**Lead Local Flood Authority
Ground Floor
Northleigh
County Hall
Chichester
West Sussex
PO19 1RH**

LU/72/25/OUT - Land West of New Courtwick Lane, Wick, BN17 7RZ

Thank you for consulting the Lead Local Flood Authority (LLFA) on the above application.

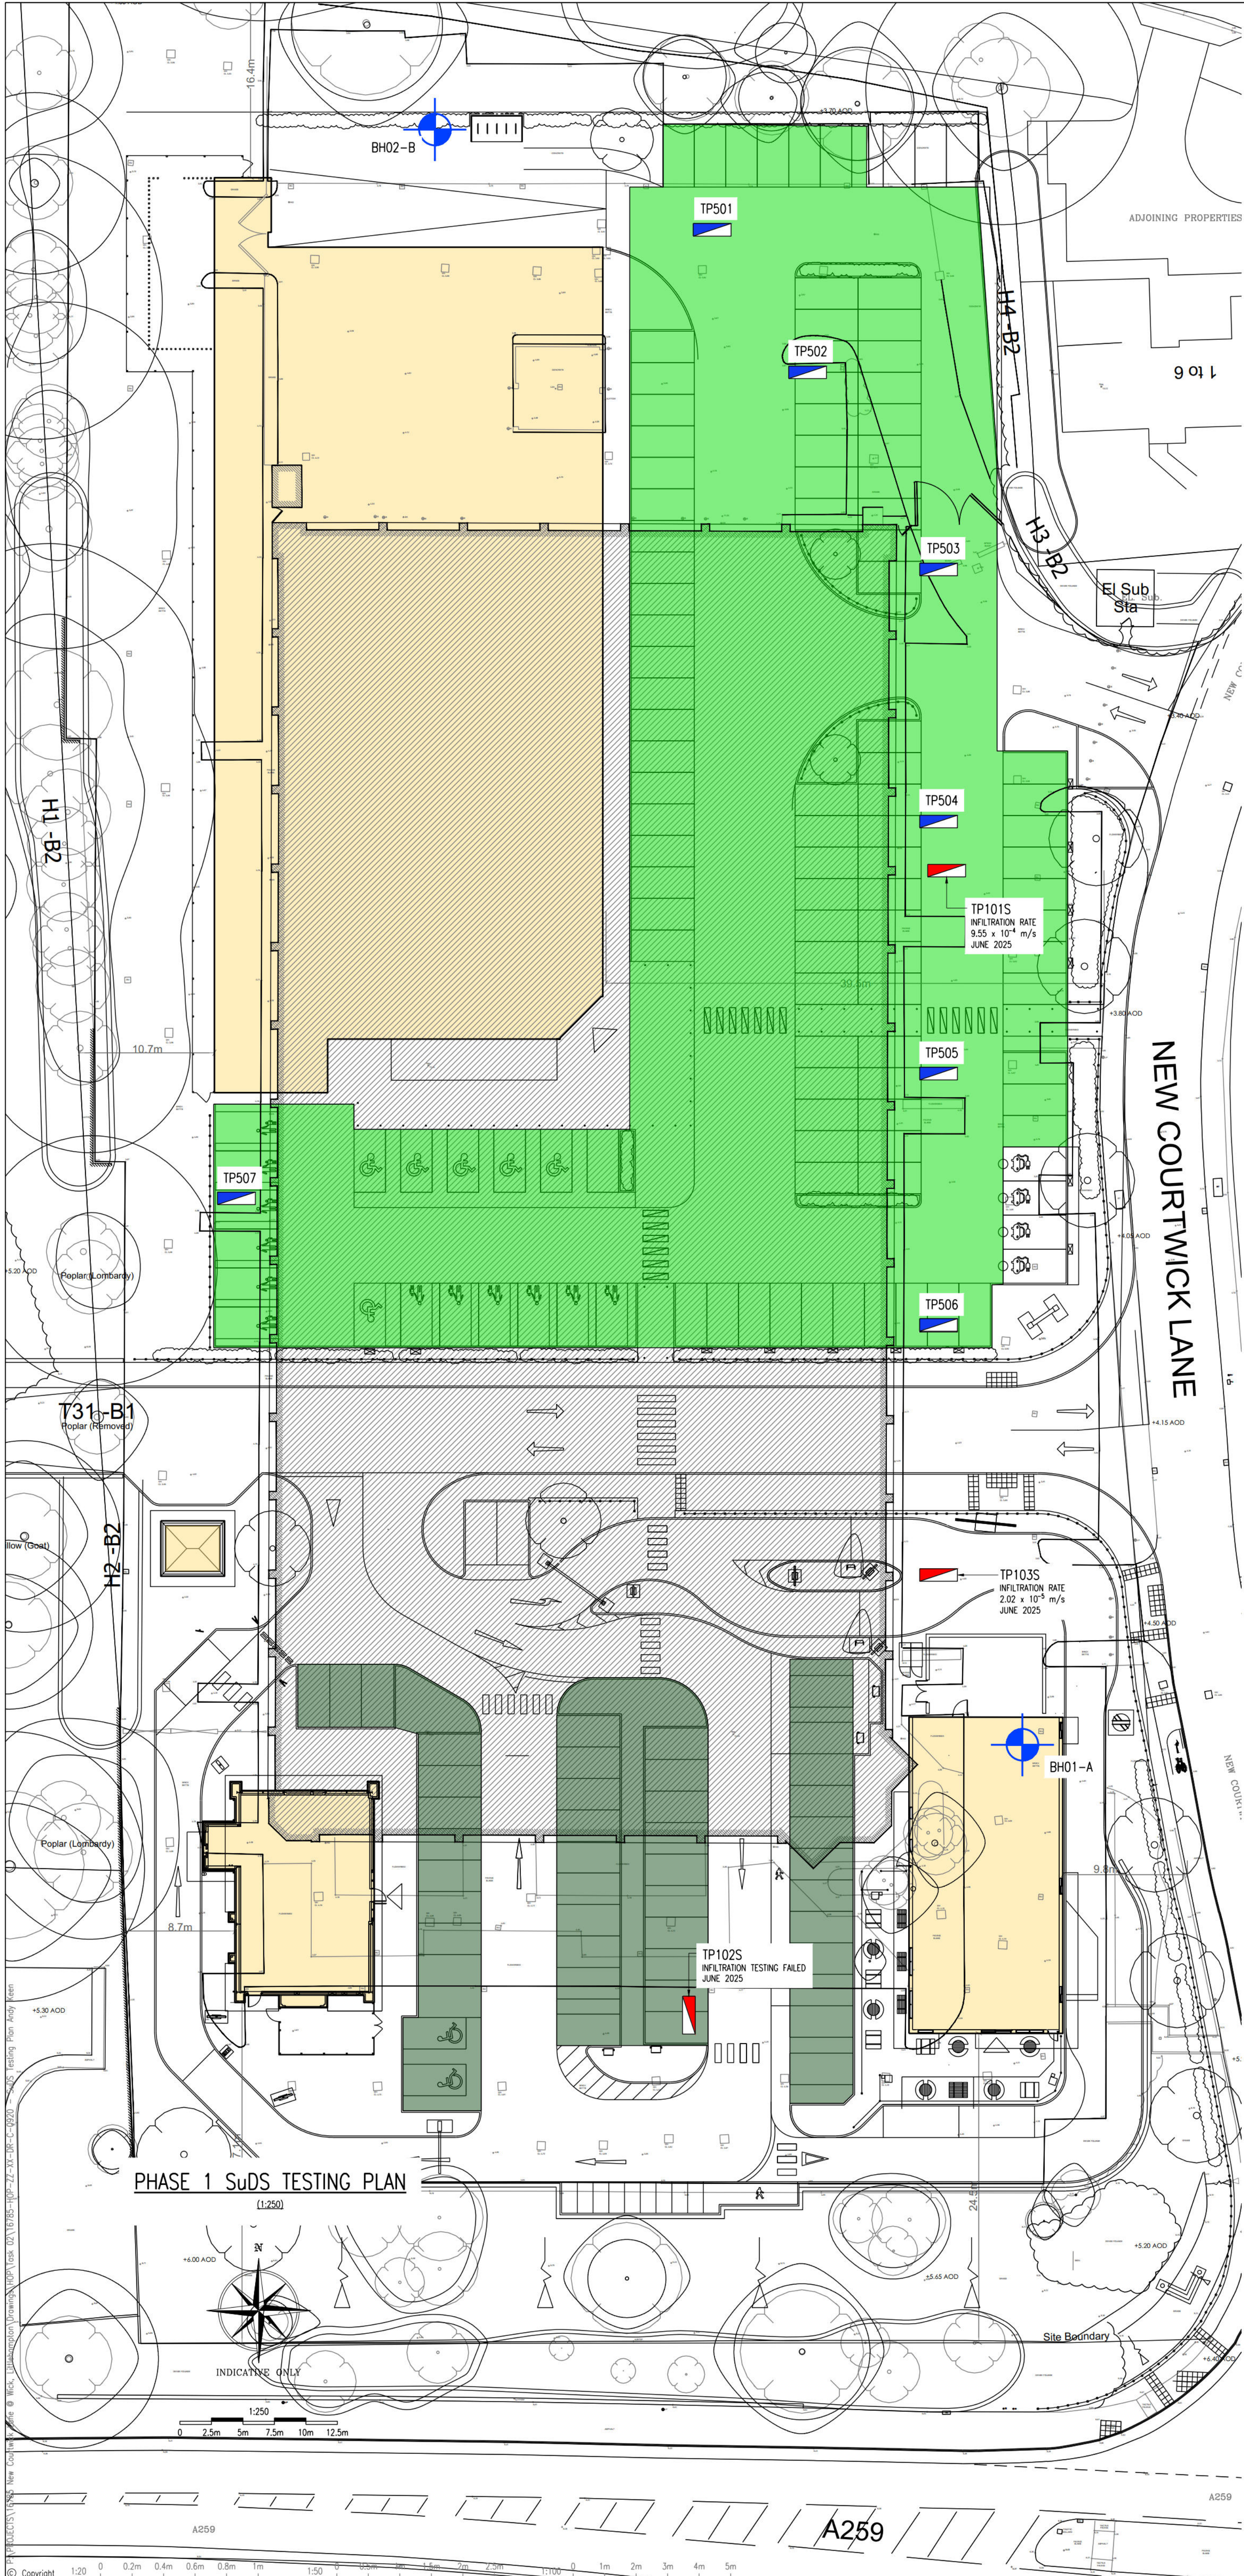
- The groundwater monitoring record remains incomplete, with no data available between 17 February and 16 March. Consequently, it is not possible to confirm that the recorded groundwater level represents the seasonal maximum. The applicant should therefore either demonstrate that the recorded level captures the seasonal peak groundwater condition or apply an appropriate factor of safety within the drainage design. **Sufficiently addressed. Applicant has demonstrated to our satisfaction that they have captured the winter peak groundwater level and provides the required buffer.**

- Given the uncertainty surrounding groundwater levels and the limitations associated with engineered stone, the proposed infiltration approach has not been demonstrated to comply with National SuDS Standard S1, which requires infiltration systems to be located within suitable ground conditions. **Partially addressed - Outstanding. Further clarification required.**
